RE: **Lot 15 Block 2 SAD 228**
Volcano Cliffs Subdivision
6508 Camino Del Oeste NW
Grading and Drainage Plan
Engineers Stamp Date 11/28/17 (D10D003G15)
Pad Certification Date: 12/4/17
CO Certification Dated: 6/7/18

Based upon the information provided in your submittal received 6/7/18, this plan cannot be approved for Certificate of Occupancy until the following comments are addressed.

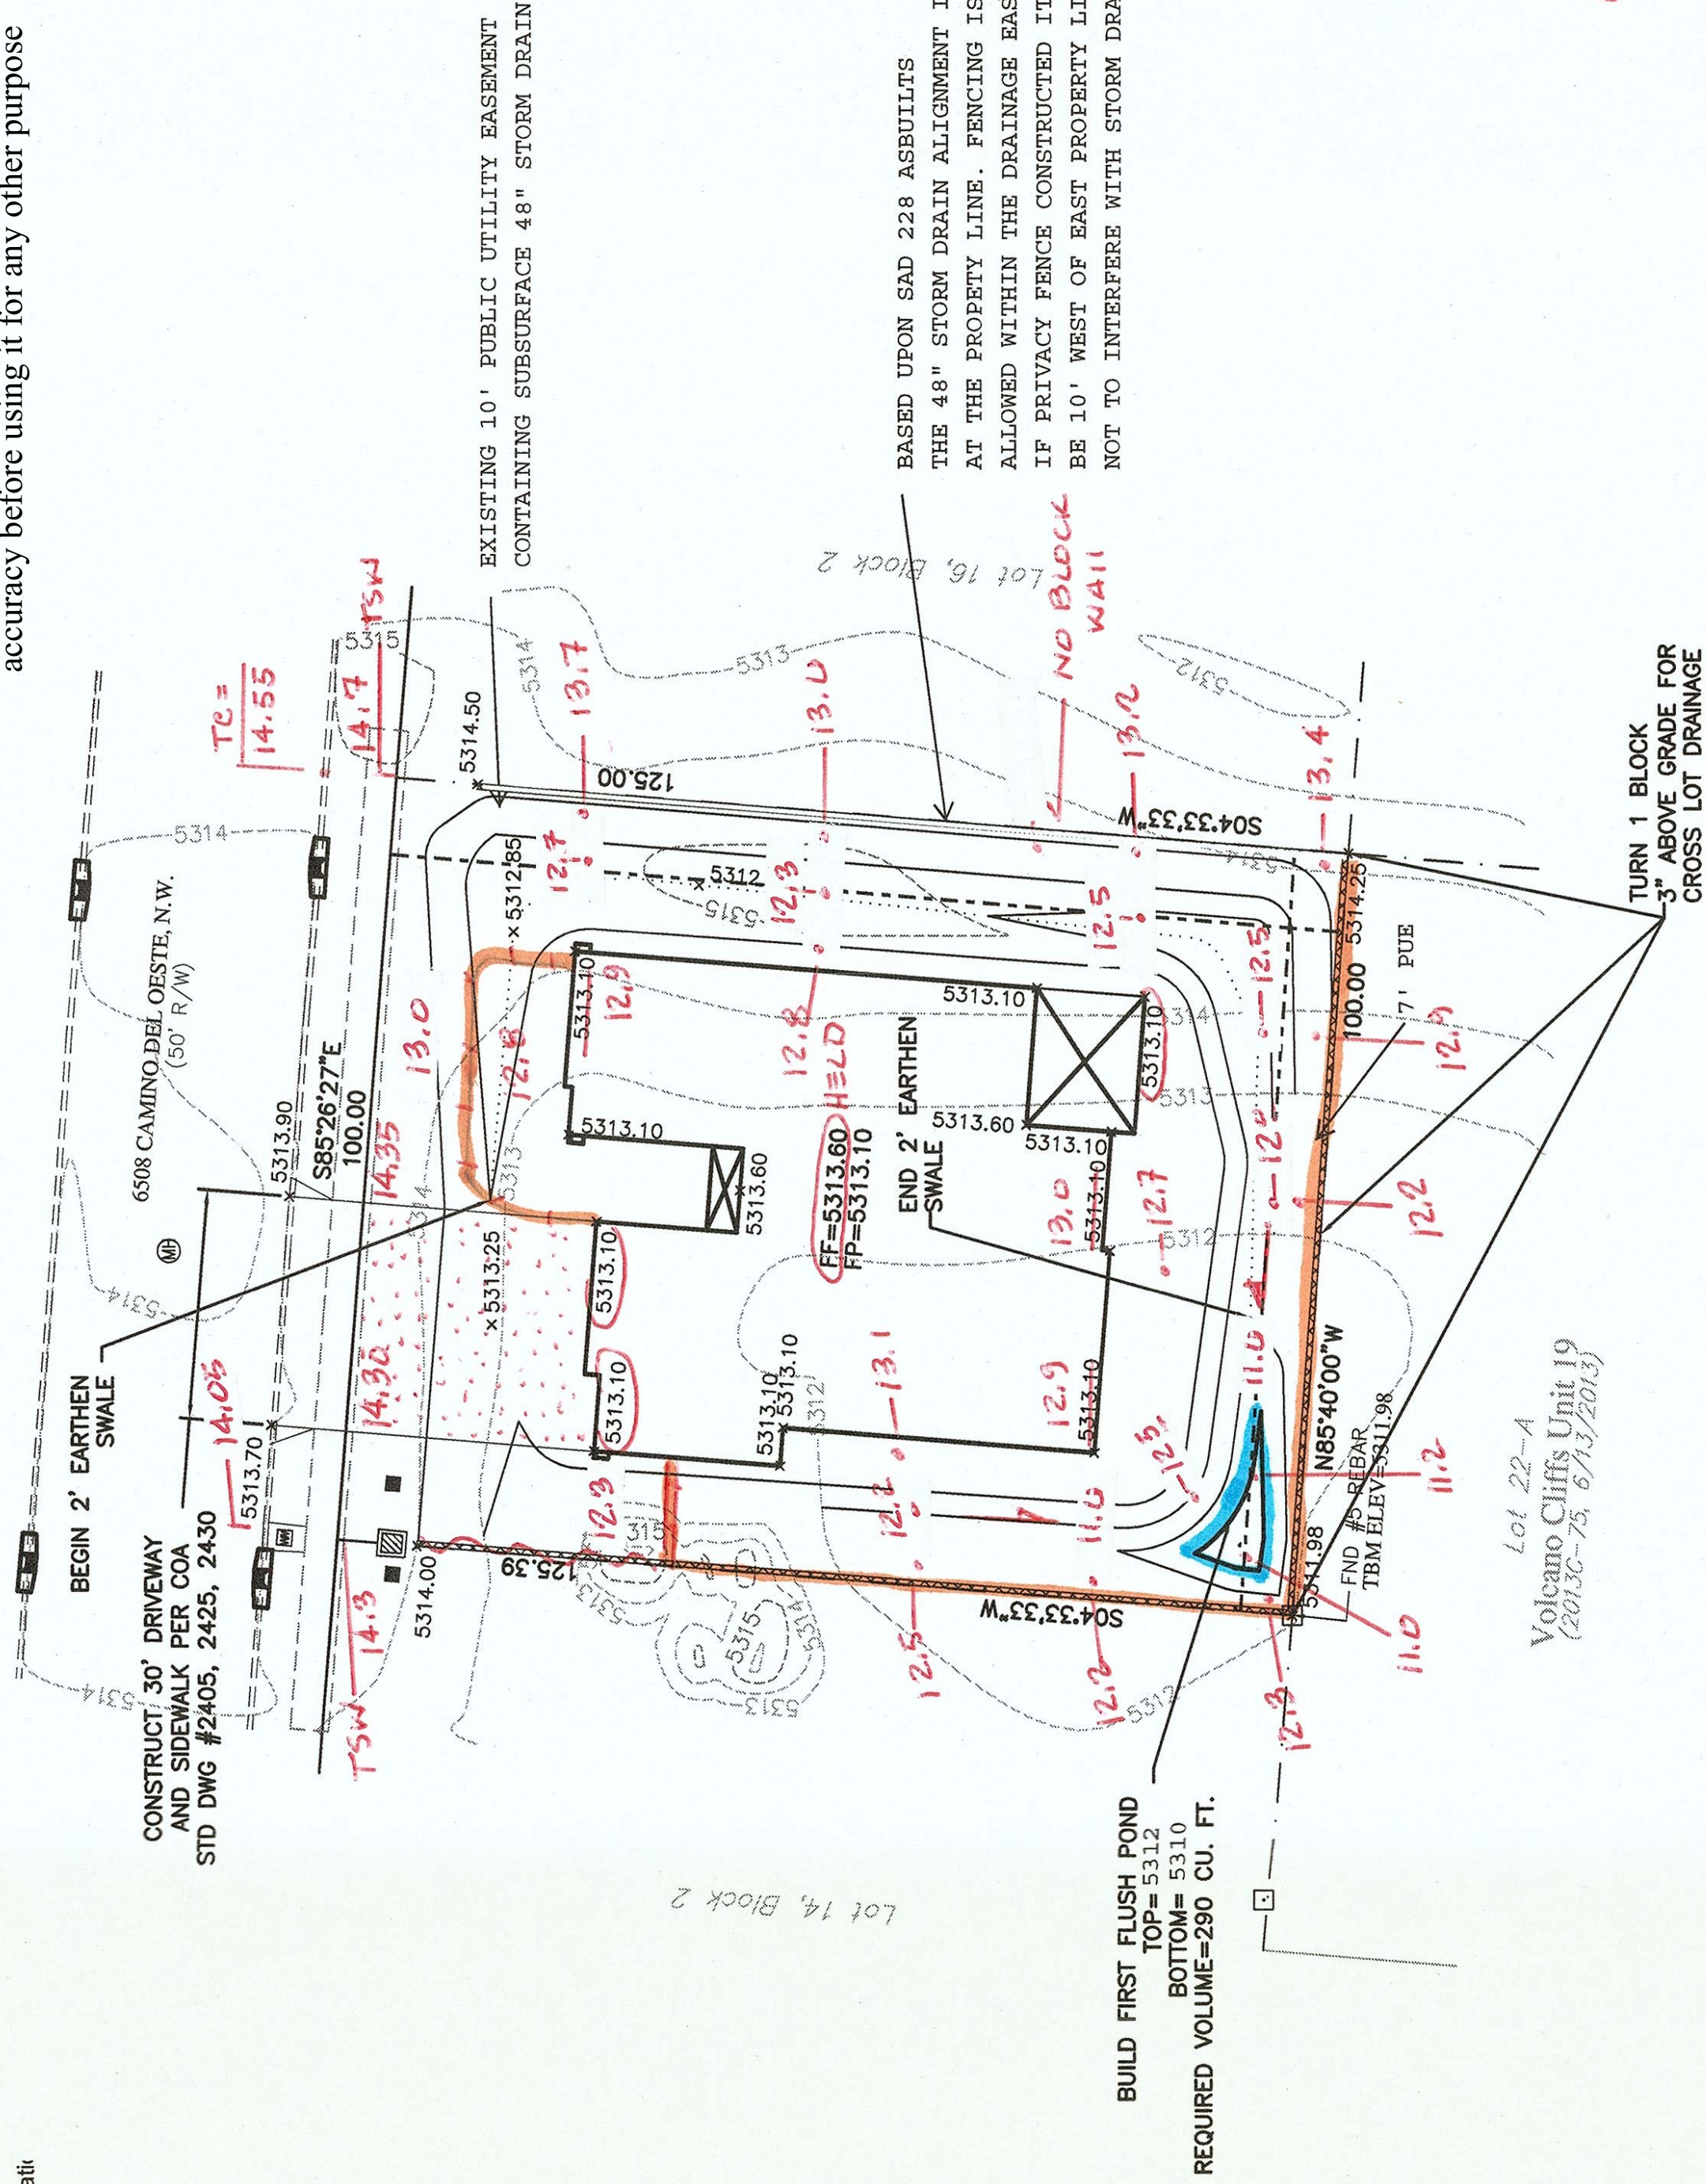
- Remove the concrete slabs in the public right of way.
- Remove all concrete and debris in and around the site.
- Remove the gravel in the street.
- Provide turn blocks as noted on the approved plan.
- Provide opening in front yard garden wall where swale is located.
